WEST YORKSHIRE POLICE

Ref: 2019/94099
Date: 18th February 2020

Site Location: Former Kirklees Council Depot, 1 – 3 St Pauls Road, Mirfield, WF14 8AX

Application Type: Two storey supported living apartment block with 13 apartments.

1:100 Site Plan

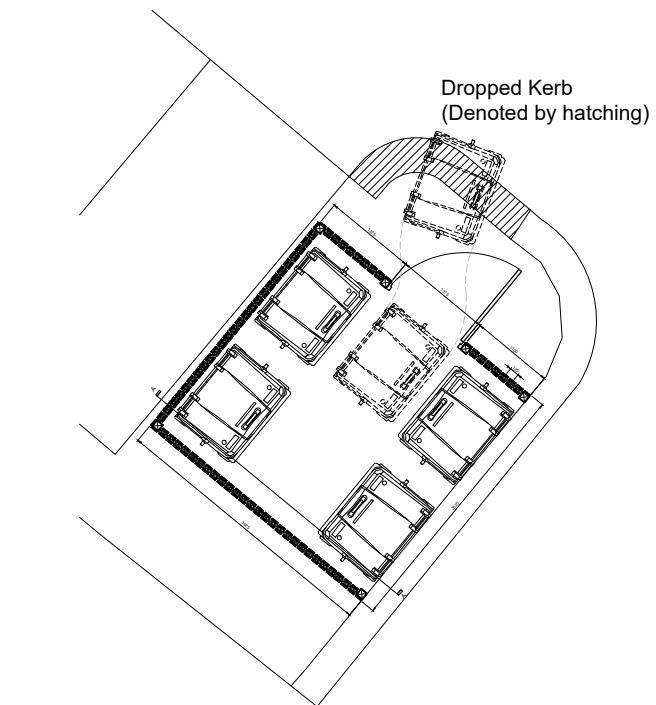
Referring to site plan drawing number **501/01(02)012 A dated 26/9/19**.

1. Lighting – Could details of the site lighting be supplied. It is a prerequisite that the following areas are included in the lighting scheme:-
Main site access, Car parking areas, All footpaths and associated areas to the main building, Main entrance doors and other access door/fire exit doors.
2. Gates (vehicular and pedestrian) – What are the designs and heights of the gates around the site? What if any are to be the gates to secure the parking area?
3. Main Communal Entrance Door – What door set standards are to be installed? Door sets should comply with Section 2a, 27 in the Secured by Design New Homes 2019 document.

5. What are the standards for the other access doors on the building including the locking systems?
6. Is there to be an alarm system and 24-hour monitoring help alarm system in the development?
7. The cycle racks are sited in the wrong place. They do not have sufficient natural surveillance from active frontages. Could these be re-sited within view of active apartments and be installed to the below standards.
